## CITY OF ALBUQUERQUE

May 12, 2023

Re: Ventura Plaza Self Storage 8041 Ventura St. NE Traffic Circulation Layout Engineer's/Architect's Stamp XX-XX-XX (D20-D010D)

Drawing file: Final / D20D010D_TCL_APPR.pdf

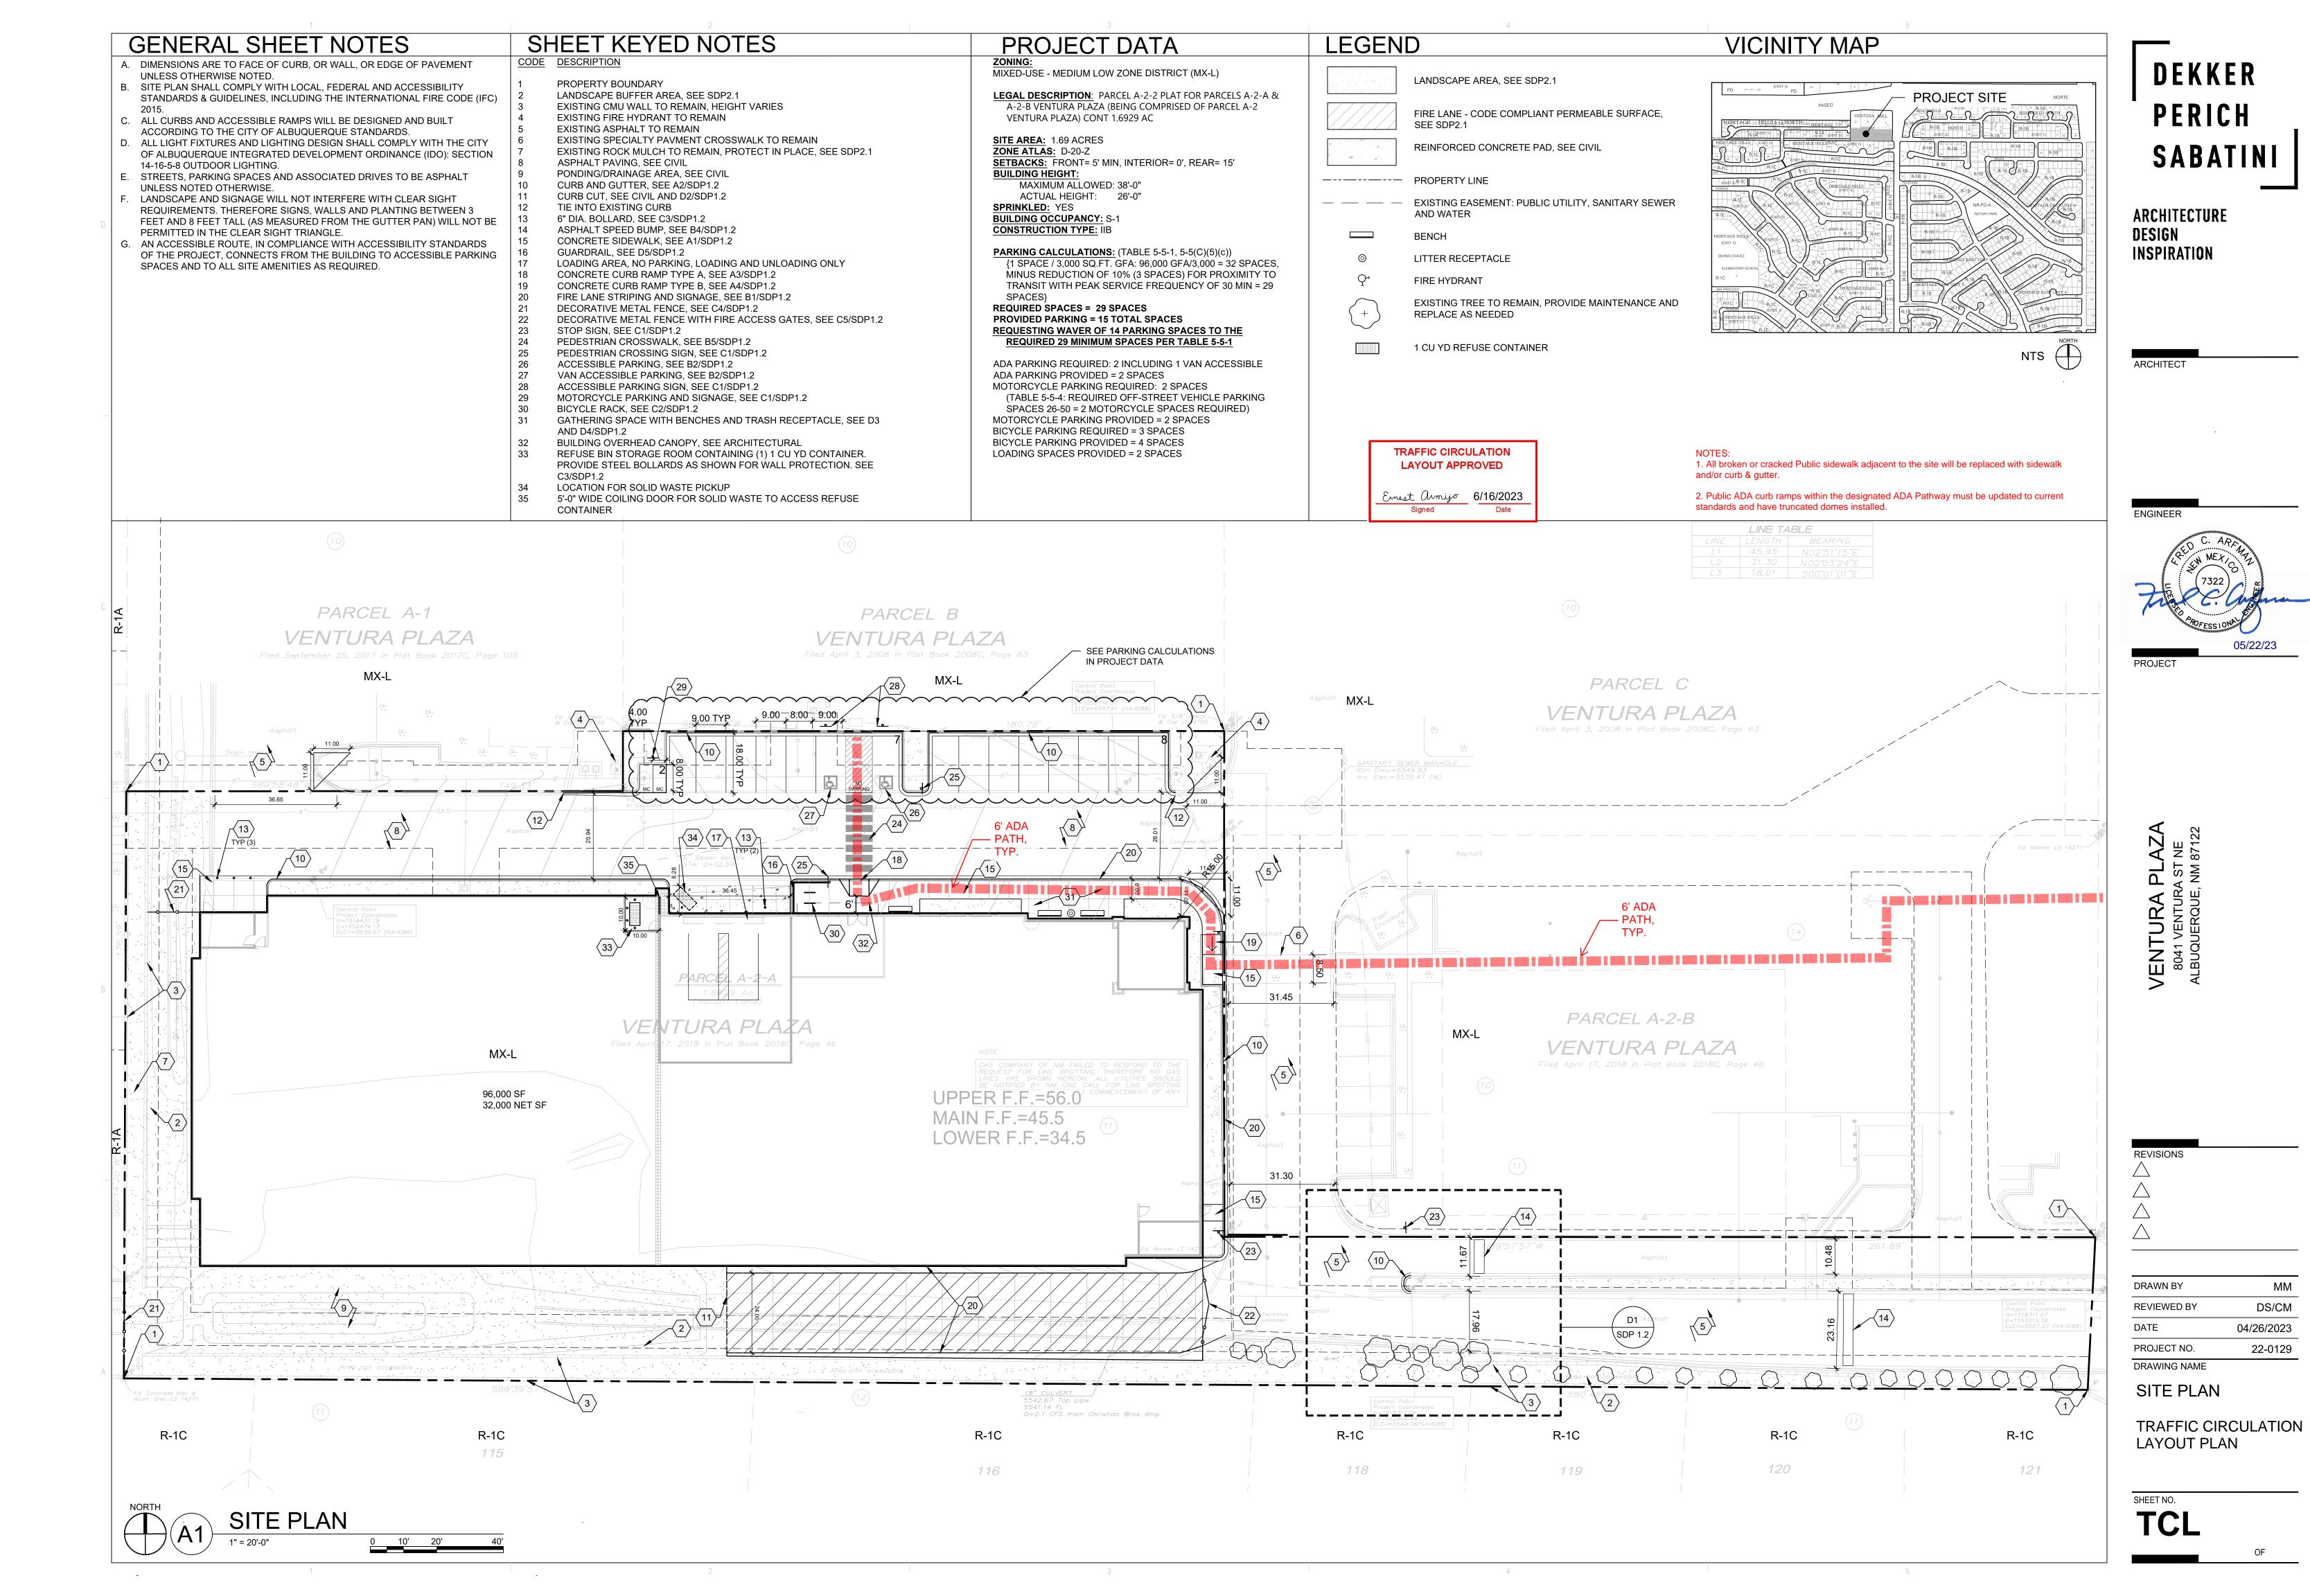
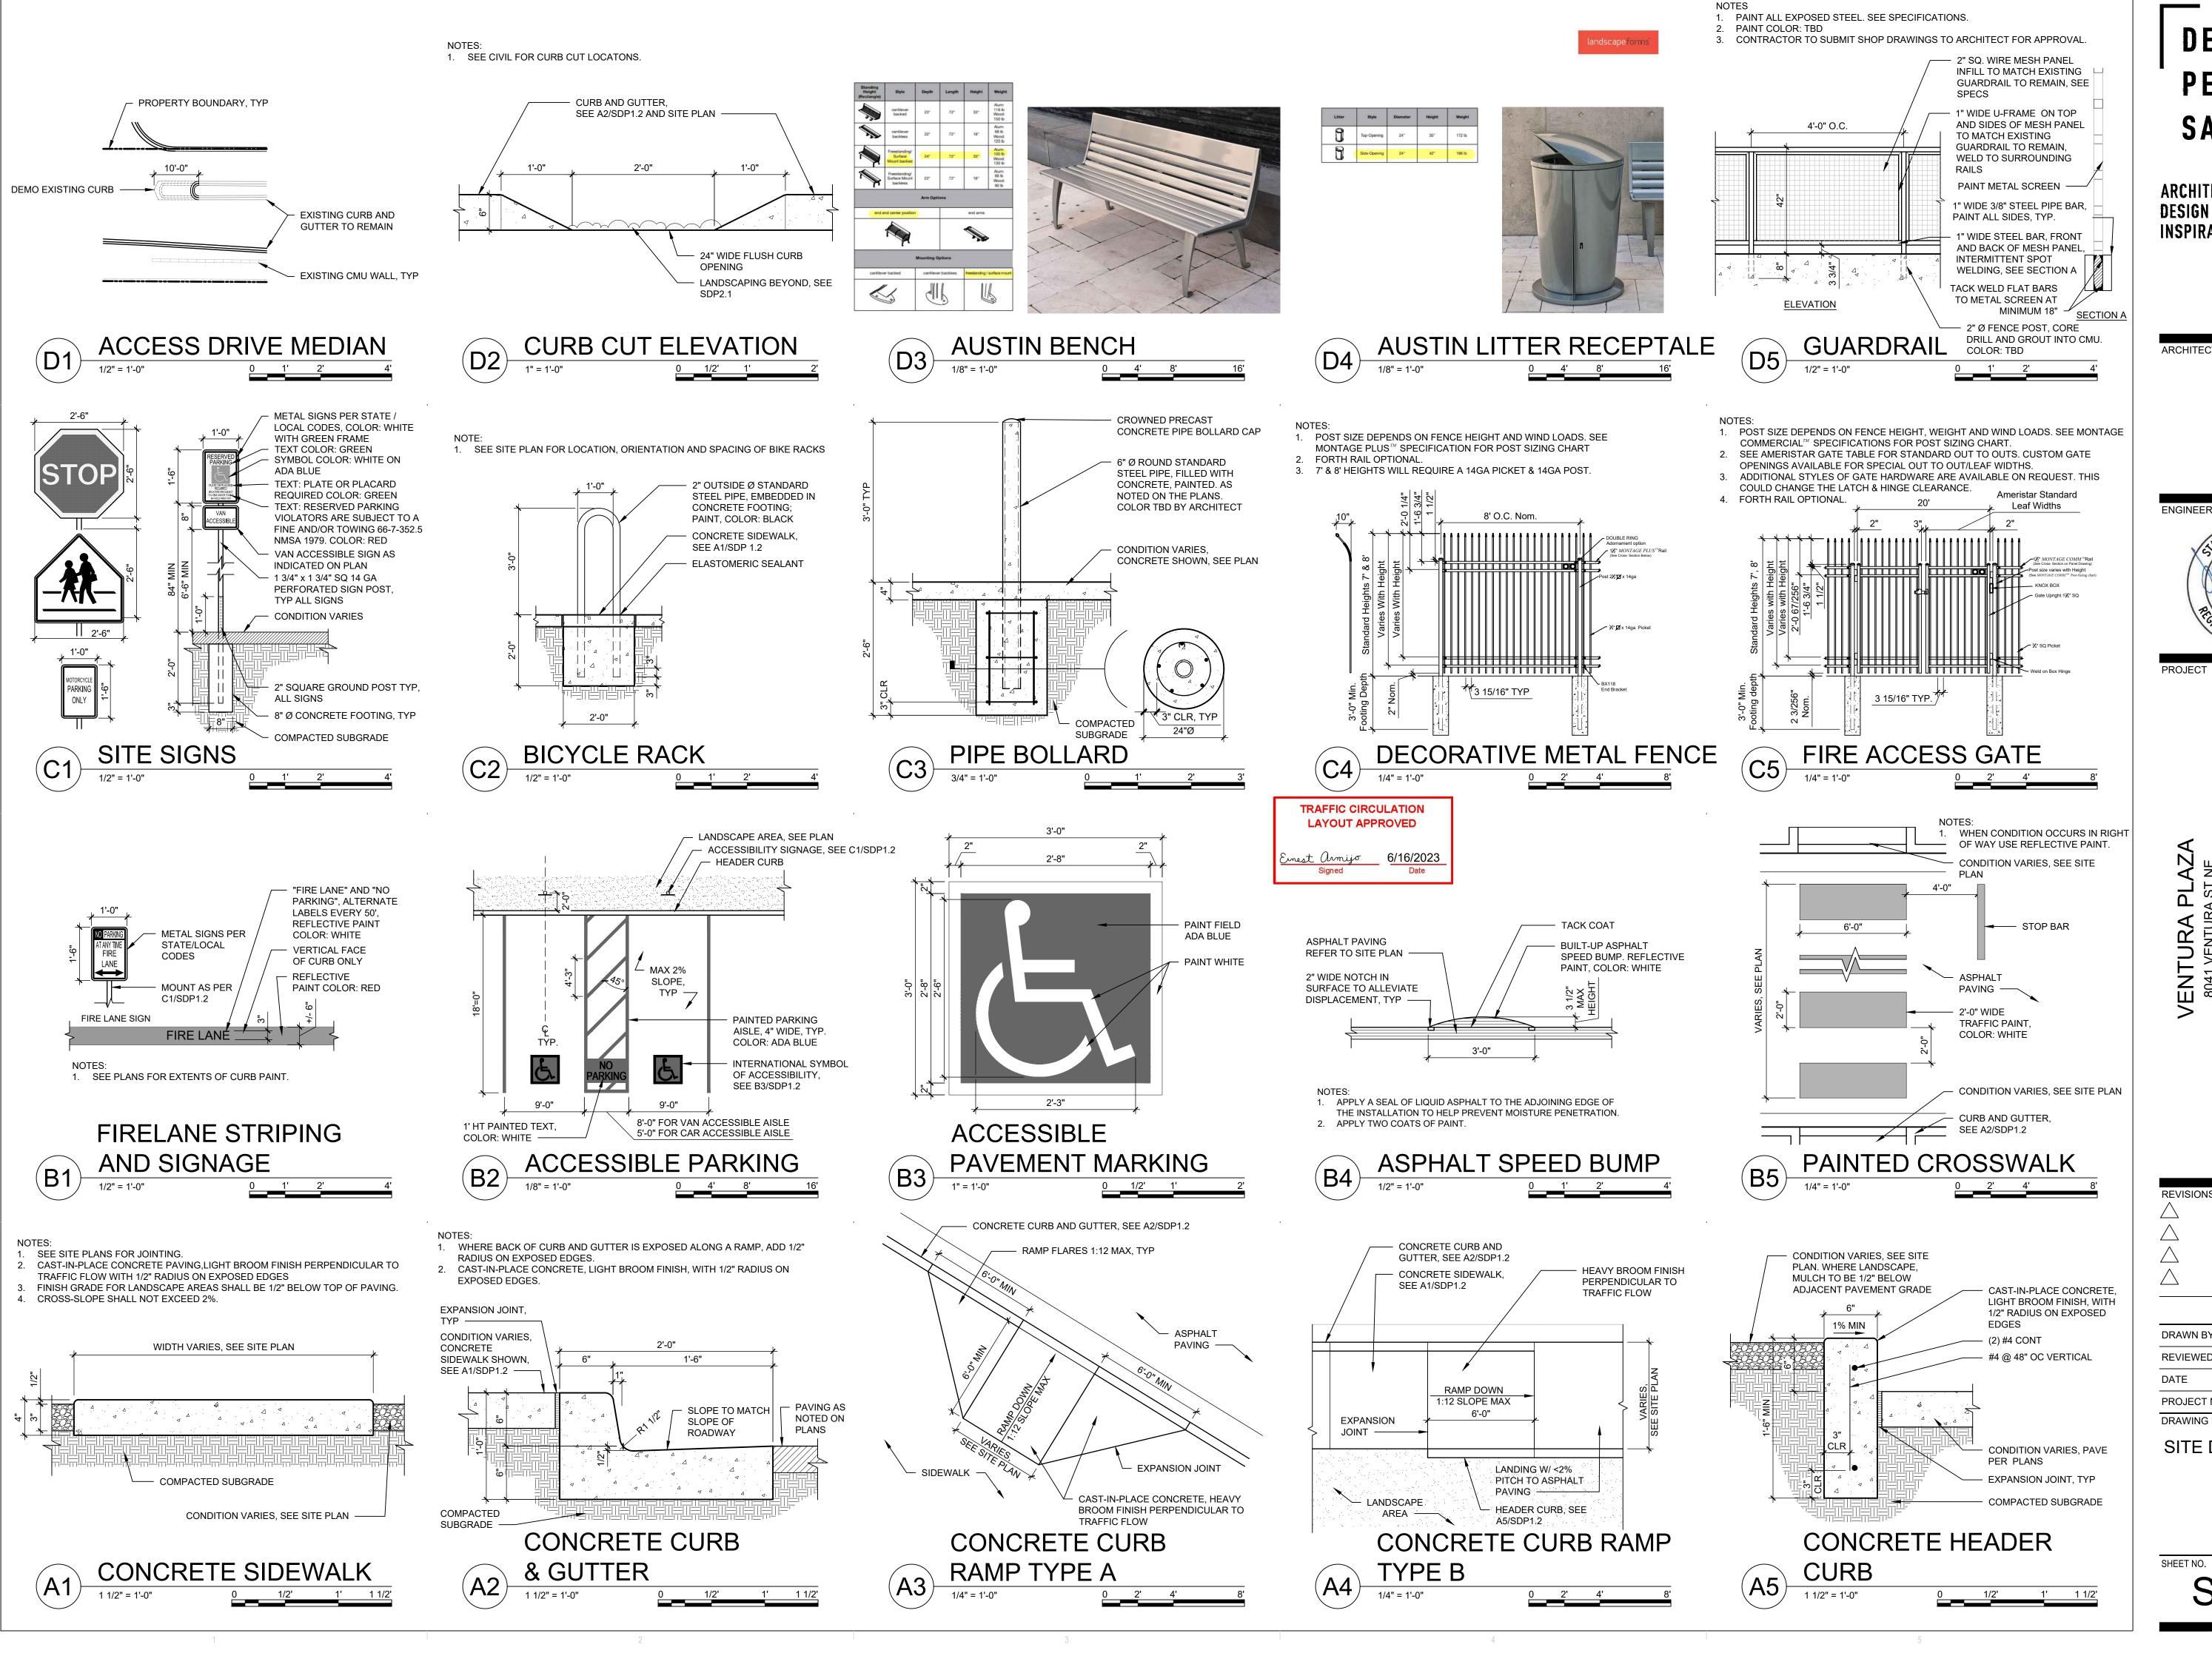
1. The traffic circulation layout must be stamped, signed, and dated by an engineer or architect licensed in the state of New Mexico.

- Sheets details are missing.
- 5. Please provide details for all the proposed ADA ramps, and reference COA std dwg.

6. The ADA accessible parking sign must have the required language per 66-7-352.4C NMSA 1978 "Violators Are Subject to a Fine and/or Towing." Please call out detail and location of signs.

- 7. The ADA access aisles shall have the words **"NO PARKING"** in capital letters, each of which shall be at least one foot high and at least two inches wide, placed at the rear of the parking space so as to be close to where an adjacent vehicle's rear tire would be placed. (66-1-4.1. B NMSA 1978)

- 8. ADA curb ramps must be updated to current standards and have truncated domes installed.
- 9. Motorcycle parking spaces shall be designated by its own conspicuously posted upright sign, either free-standing or wall mounted per the zoning code.

- 10. The pavement marking "MC" should be shown in the opposite direction for motorcycles entering the parking space.
- 11. All bicycle racks shall be designed according to the following guidelines:

- 15. Per the IDO, a 6 ft. wide ADA accessible pedestrian pathway is required from the public sidewalk to the building entrances. Please clearly show this pathway and provide details.

- 16. Per DPM, a 6 ft. wide ADA accessible pedestrian pathway is required from the ADA parking stall access aisles to the building entrances. Please clearly show this pathway and provide details. Please show this dimension on the site plan.

FIRE APPARATUS TURNING RADIUS
1"=30'

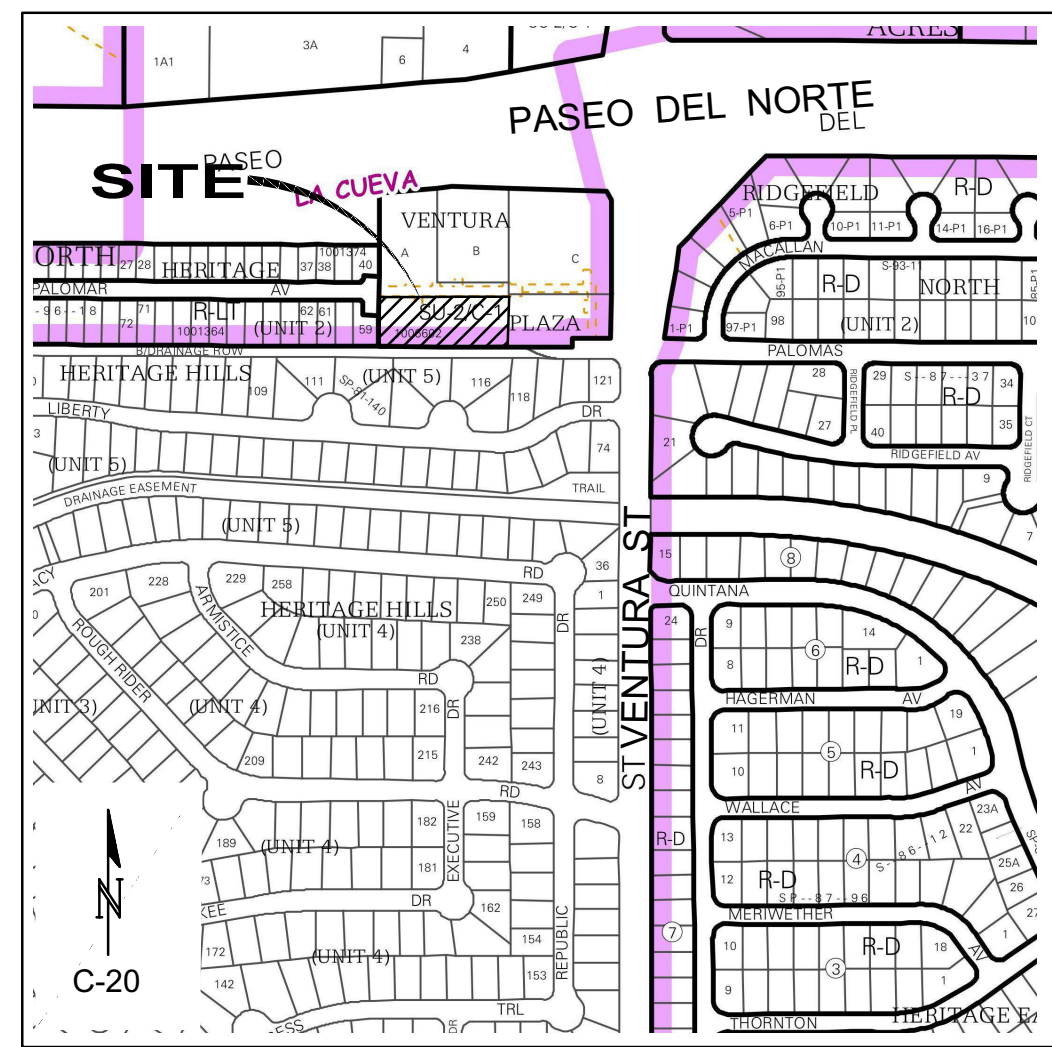
- 18. Provide a copy of Fire Marshal approval.
- 19. Please specify the City Standard Drawing Number when applicable.
- 20. Add a note stating "All broken or cracked sidewalk must be replaced with sidewalk and curb & gutter." A build note must be provided referring to the appropriate City Standard drawing.
